Planning Application Reference No.: 3/2026/0698

Address of Development: Thorn Street Garage Clitheroe BB7 1DN

Comments: Planning Application No 3/2026/0698
Thorn Street Garage Clitheroe BB7 1DN

Client: Rufus Carr Ltd		
Project: Proposed Alterations Thorn Street Garage Thorn Street Clitheroe		
Dwg title: Proposed Site Plan		
Scale @ A4: 1:200	Date: 22.07.26	Drawn by: PD
Drawing no. 1830 - 102		Rev: -

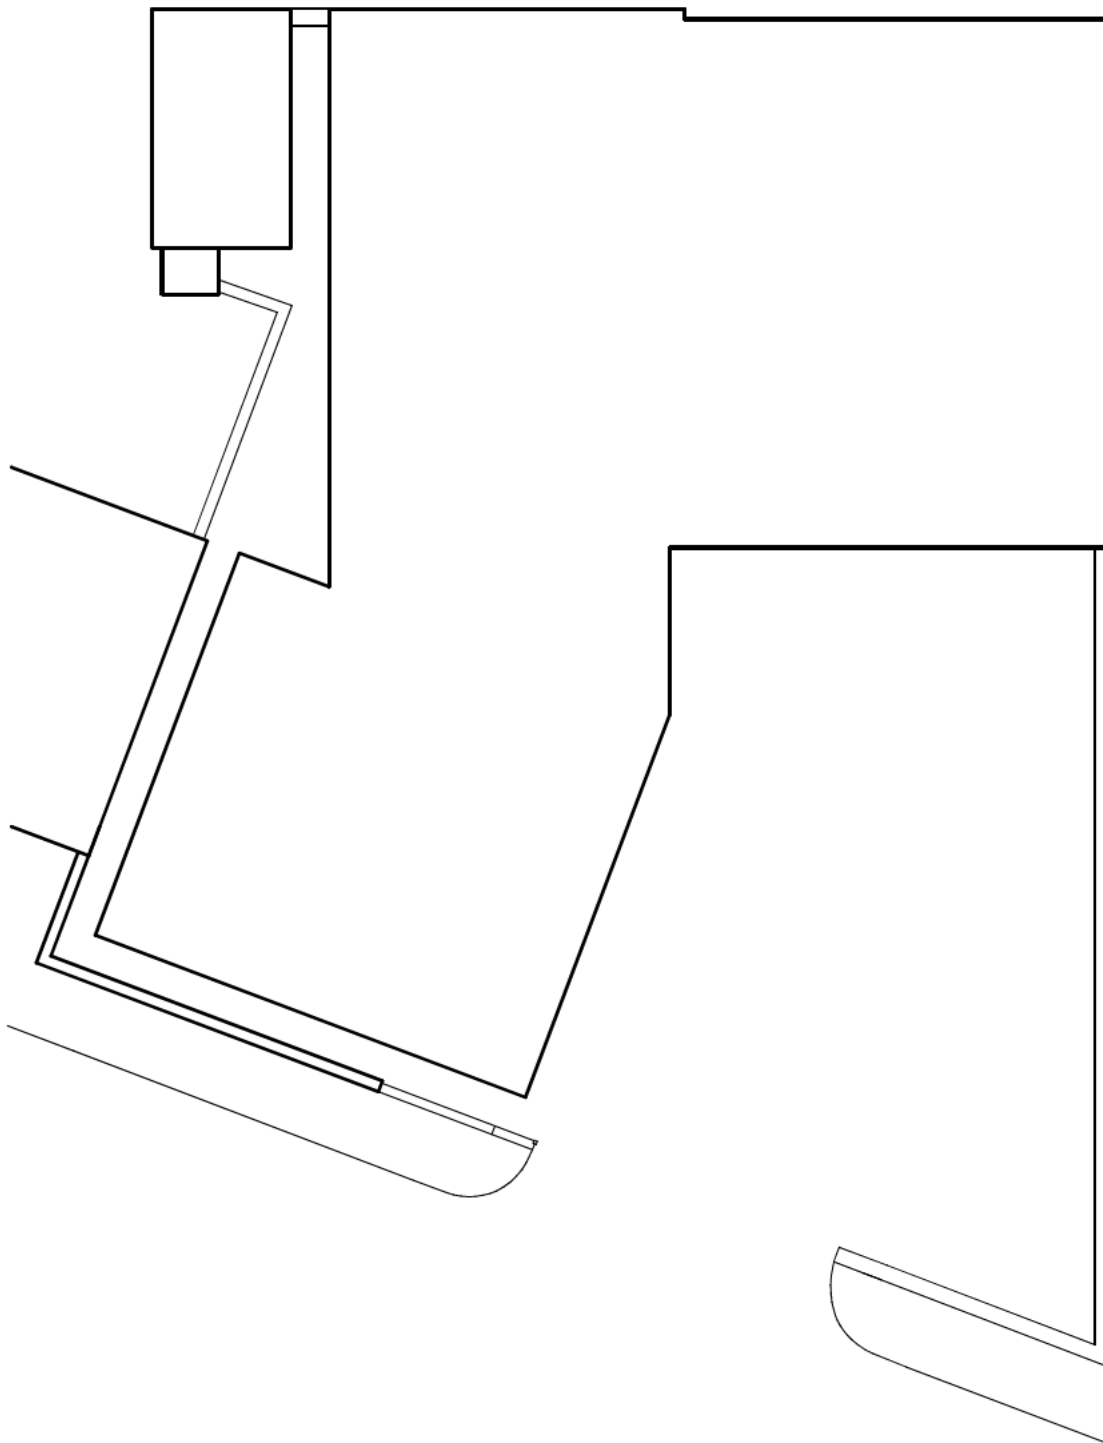
The planning application shows a spray booth to be situated at the north side of the unit adjacent to the north boundary wall.

This boundary wall is less than 4.0metres from the south boundary of adjacent residential buildings. I am very concerned that the very close proximity of the spray booth to the residential properties cannot surely comply with COSHH, HSE, Environment Health, British Standards, planning law and, perhaps, many other rules and regulations.

I am been made aware that to ensure adequate chemical dispersion, an exhaust stack must usually terminate at least 1.0 to 3.0 metres higher than the roof ridge of the building it is housed in and often higher than any residential roof line in close proximity to the spray booth exhaust stack to ensure fumes clear homes before dispersing.

Comments: The Planning application shows a spray booth at the north side of the unit. The boundary wall is less than [REDACTED]. I am concerned that the close proximity cannot comply with environmental health and planning law. Please confirm the paint spray booth is completely filtered against any escape into the surrounding air. Also filters used comply with noise pollution levels. Is the spray booth only to be used during daytime hours and not into evening periods?
